Your Ref: OWPC13067
Our Ref: LU/54/17/HH 15-02-2017
Please ask for:
Charlotte Spencer

Proposed extension
5 Camelia Close Littlehampton

Itemref	Quantity	Title/Name, designation, material, dimension etc	Article No./Reference
Designed by	Checked by	Approved by - date	Date
5 Camilia Close		Proposed Extension	1:50
01		Edition	Sheet

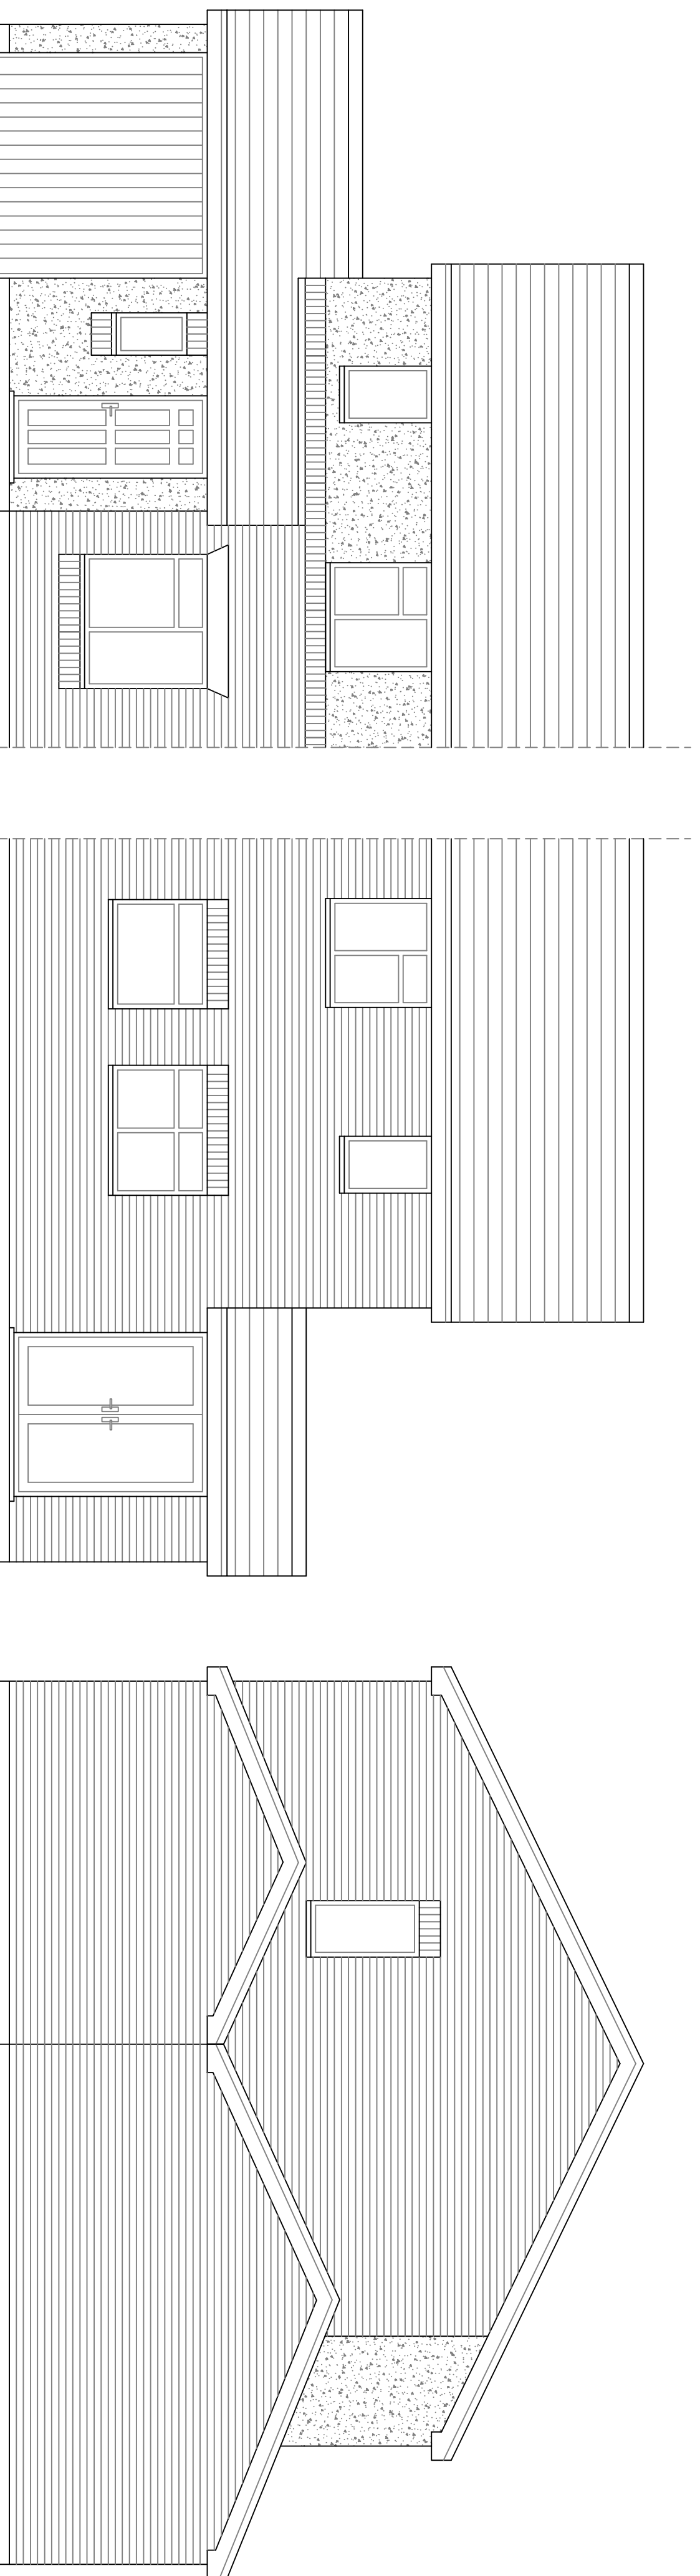
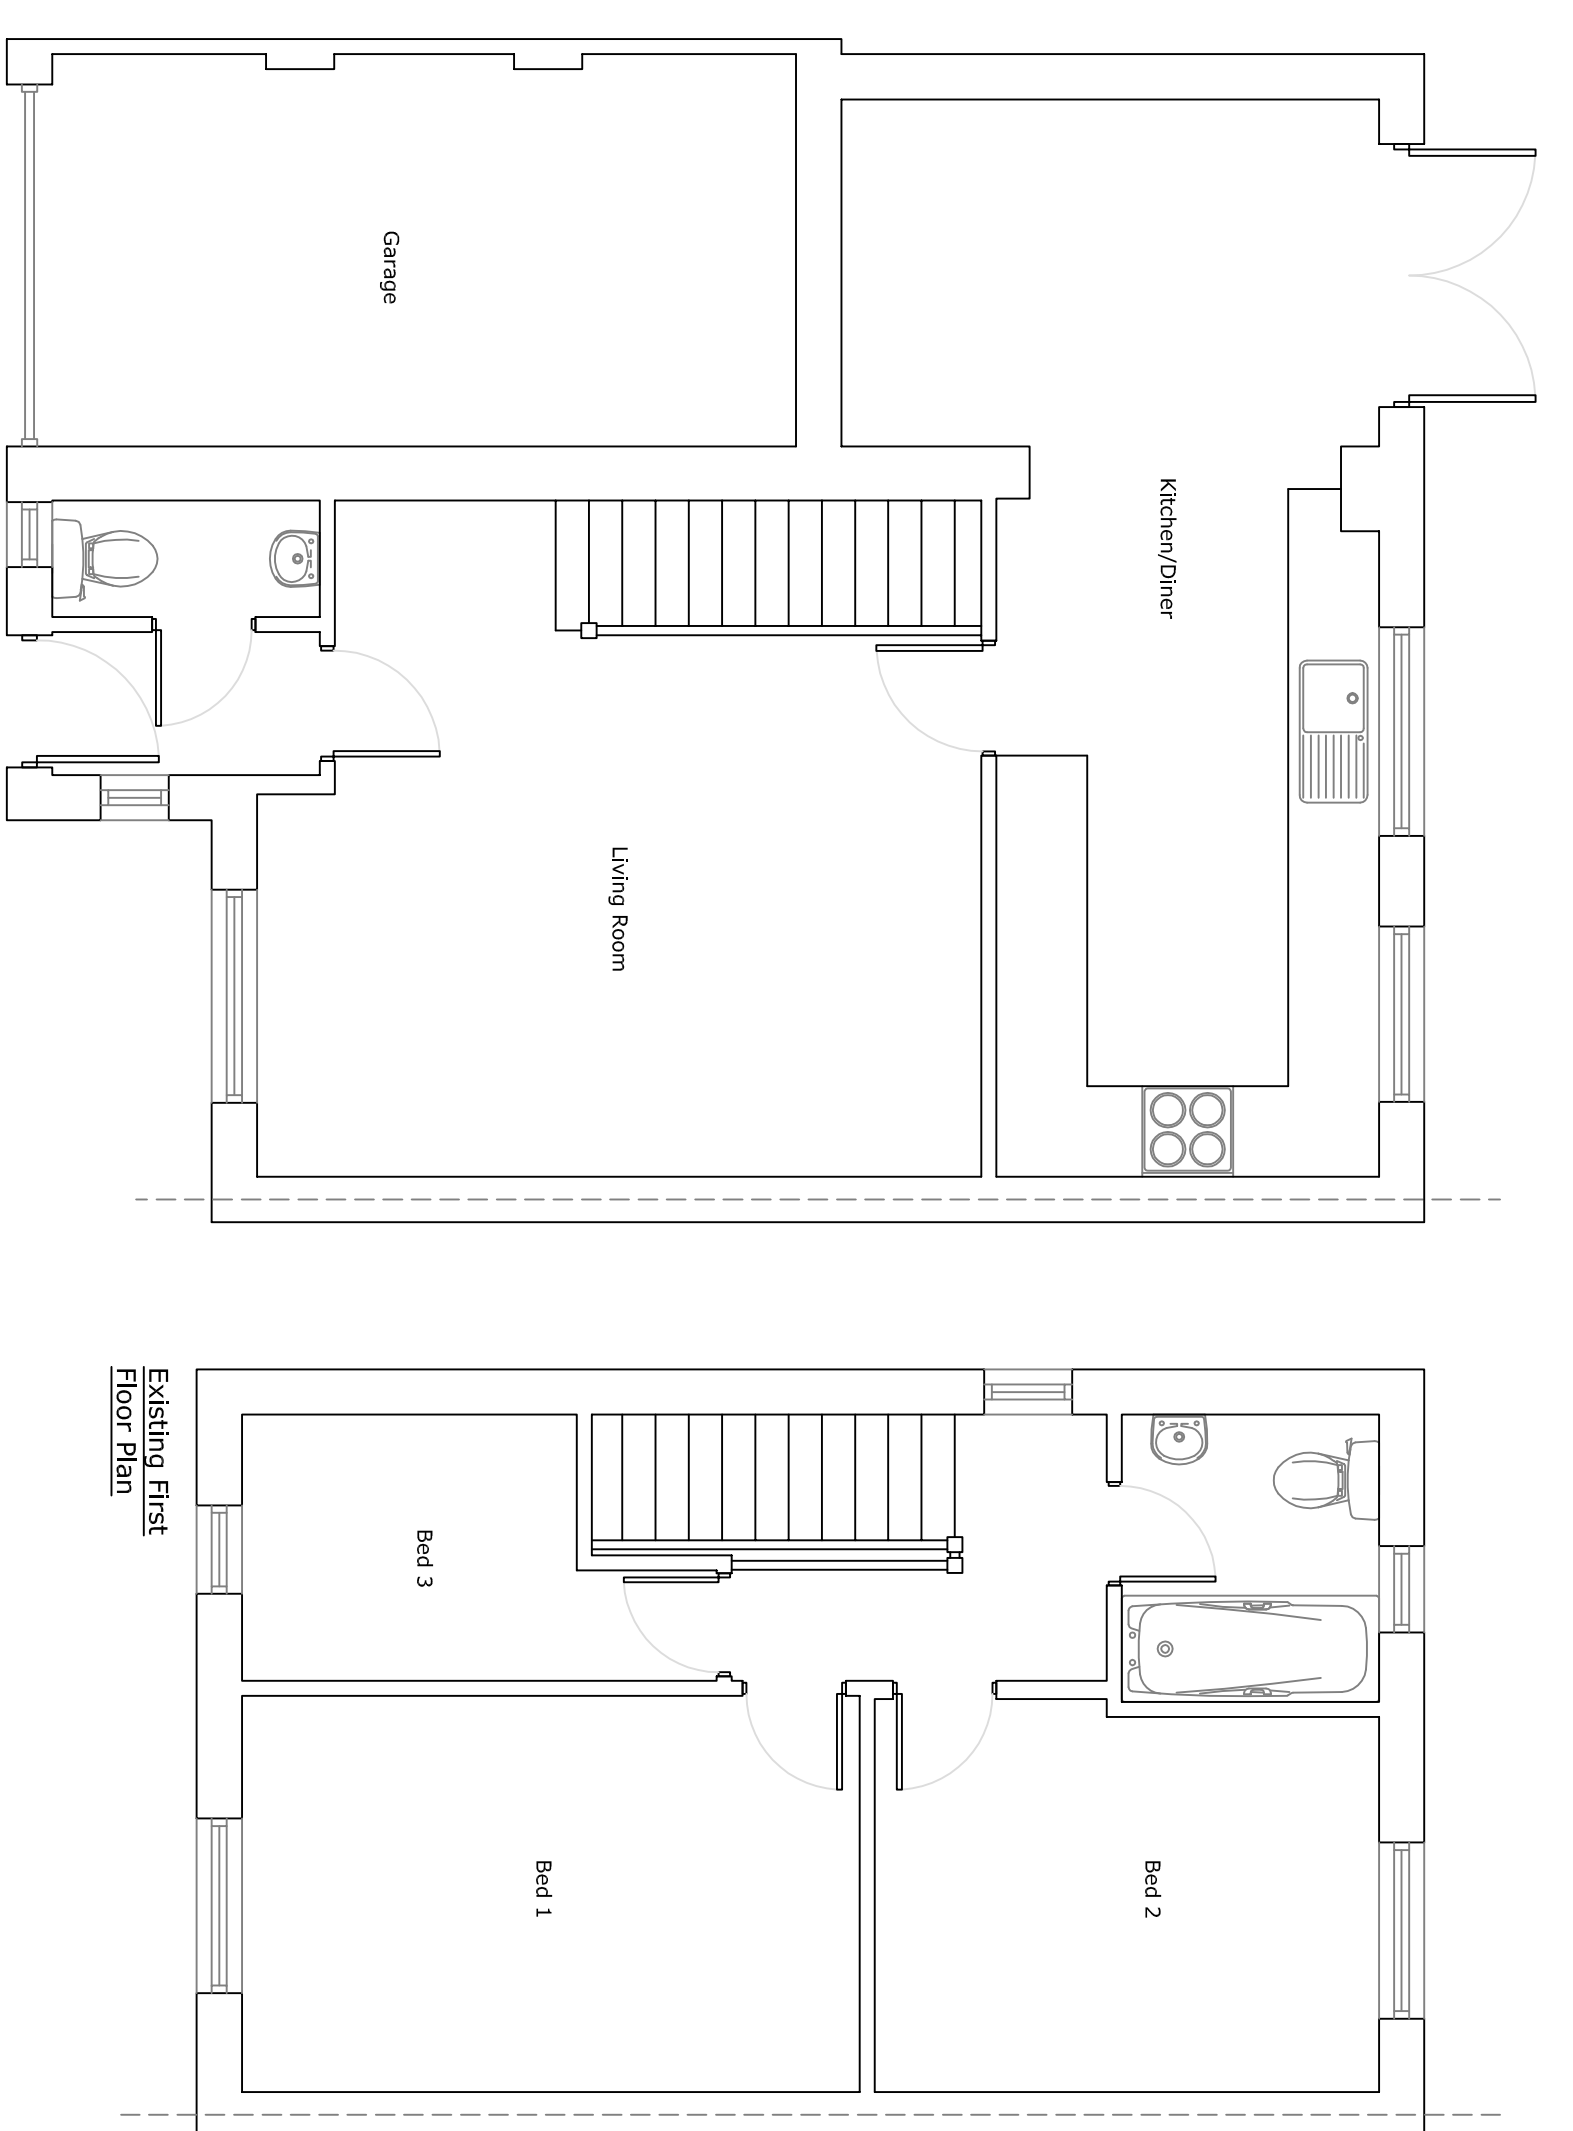
Significant increase of height to the existing extension is not in keeping with the original design of the estate and will reduce natural light and visibility encroaching neighbouring surroundings.

In particular, the morning sunshine footprint will be reduced on the existing patio area and conservatory of No 29 Bluebell Drive located adjacent to the back garden of 5 Camelia Close.

The natural air spacing between No's 5 and 3 at second story and roof line will effectively be removed. This gapping is already at a premium for houses along the west side of Camelia Close.

The inclusion of roof lights is not in keeping with the estate design.

Lastly, the permanent removal of the garage facility to that of play room removes secure parking facility for both current and future occupants, amplifying an already under pressure parking situation within that close that with the proposed increased living space will attract potential future demand.
